No To Derryadd Community Group  
Magheraveen  
Lanesboro  
Co. Longford  
[notoderryadd@gmail.com](mailto:notoderryadd@gmail.com)  
Date: 21/05/2026

An Coimisiún Pleanála  
64 Marlborough Street  
Dublin 1  
D01 V902

**Re: Objection to Case reference: PAX19.324161 Proposed development of 15 no. wind turbines, a permanent 220kV on-site substation, and associated infrastructure**

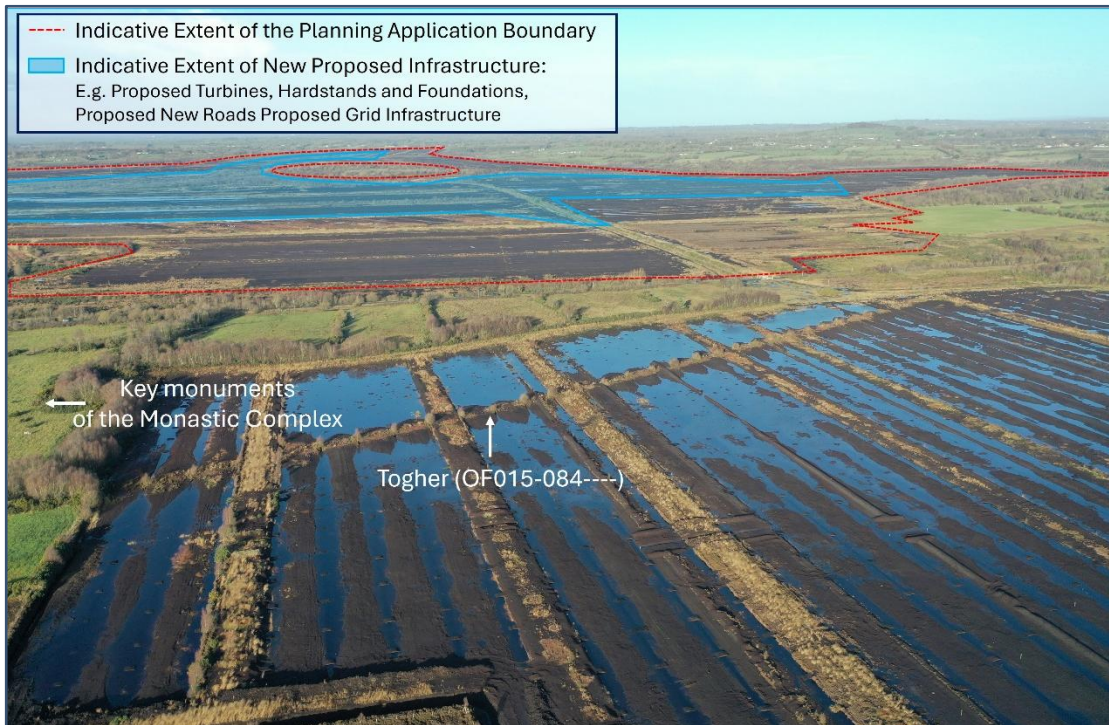
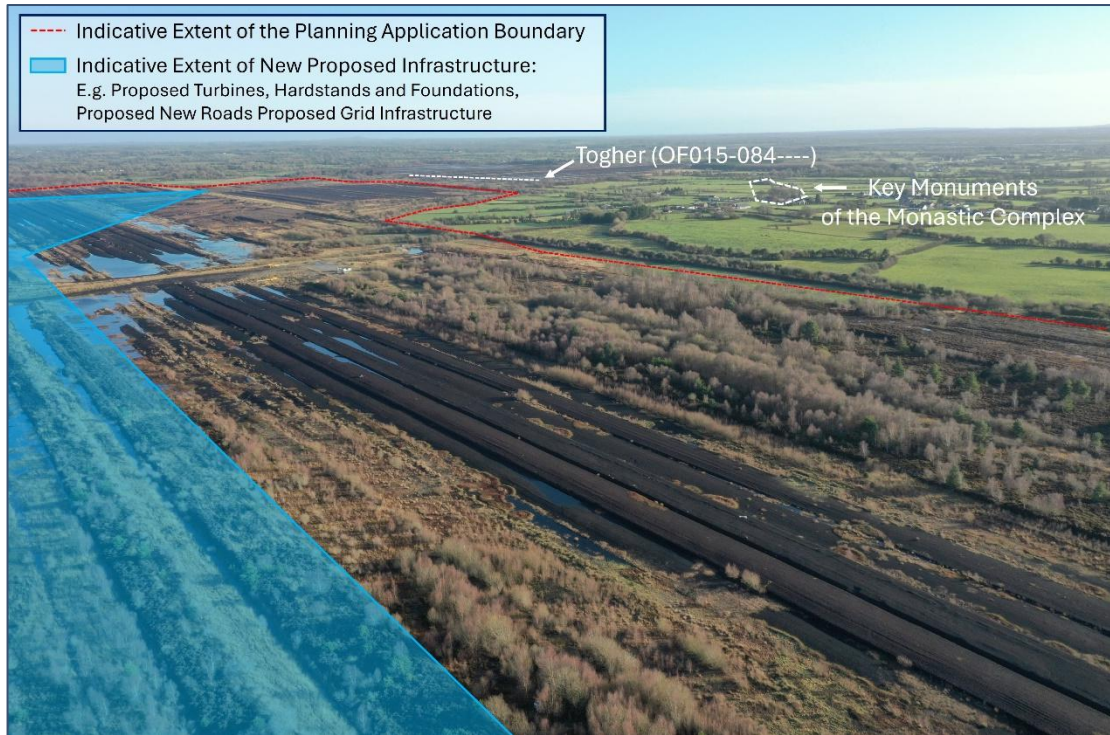
**(b)** The photomontage from VP13 (Lemanaghan Monastic Site) shows direct visual intrusion by multiple turbines from within the monastic enclosure. The landscape and visual assessment must address, with specific methodology, the concept of "setting" as defined in the Department of Housing, Local Government and Heritage, *Architectural Heritage Protection Guidelines* (2011) and as applied in the Office of Public Works heritage assessment guidelines. The EIAR Chapter 14 LVIA methodology relies on landscape character area assessments but does not apply a specific setting impact methodology to scheduled/recorded monument viewpoints in accordance with the ICOMOS approach to setting assessment.

Figure 1-7 Zoomed view of County Offaly 2021 Amended Wind Energy Zoning highlighting location of turbine T05

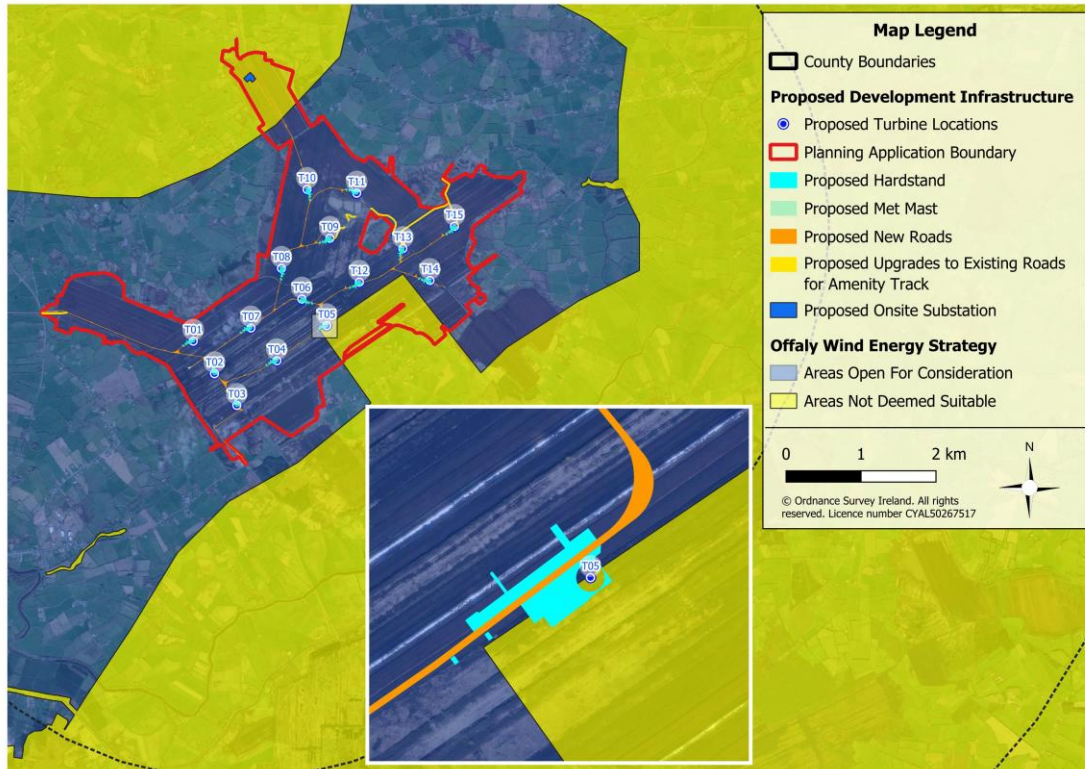
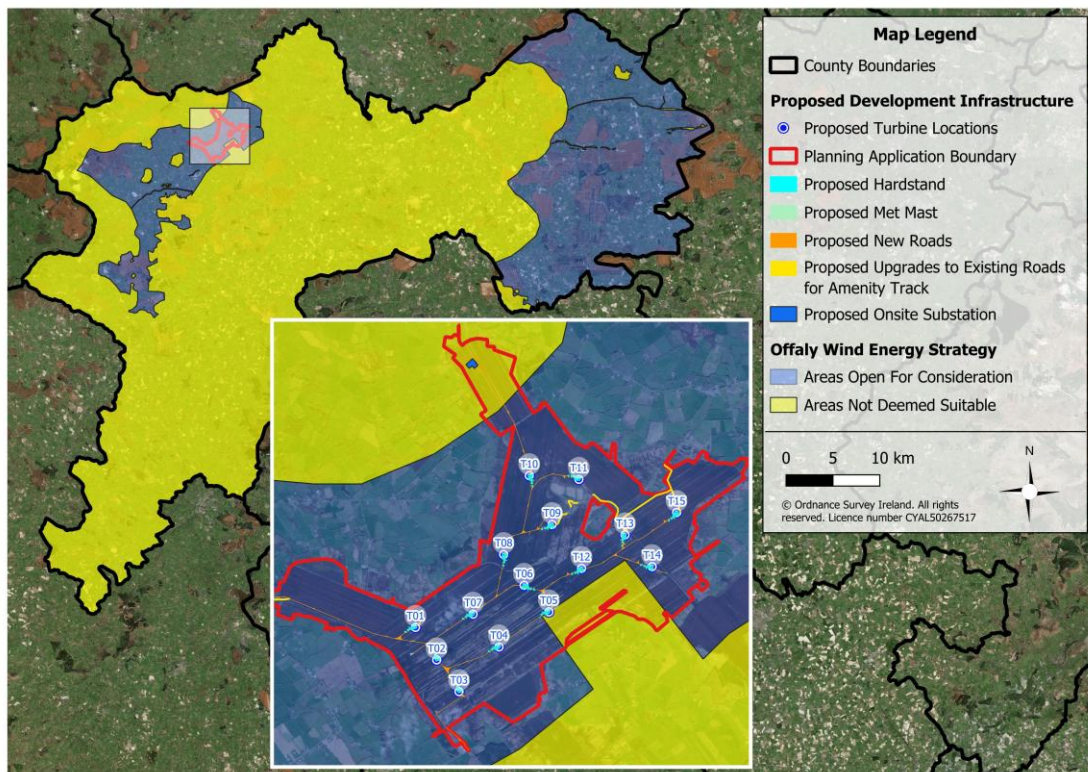
The Planning Report at Section 3.2 and the Non Technical Summary acknowledge that Turbine T05 is located on the boundary of an area designated "Not Deemed Suitable for Wind Energy Developments" under the Offaly Wind Energy Strategy 2021-2027, which forms part of the Offaly County Development Plan 2021-2027.

Objective WE-O-3 of the OCDP states that wind energy developments in areas designated as "not deemed suitable" will not be supported.

The applicant's justification that the overlap is "minor" and will not give rise to significant environmental effects does not address the planning policy non-compliance as a discrete ground. The Wind Energy Strategy designation is not a guideline or aspiration; it is a binding spatial designation in a statutory development plan. Policy non-compliance with a development plan wind energy strategy designation requires that the Commission, in exercising its function under s.37G of the Planning Act, have regard to the development plan and material considerations. The applicant has not demonstrated that the location of T05 within the "not deemed suitable" zone is justified by any specific material consideration capable of outweighing the statutory designation.

Furthermore, the application does not contain a redesign analysis demonstrating whether T05 could be relocated outside the "not deemed suitable" boundary without material reduction in the generating capacity of the project, or whether its removal would be a viable design alternative under the EIA Directive's requirement for consideration of reasonable alternatives (EIAR Chapter 3, Site Selection and Reasonable Alternatives).
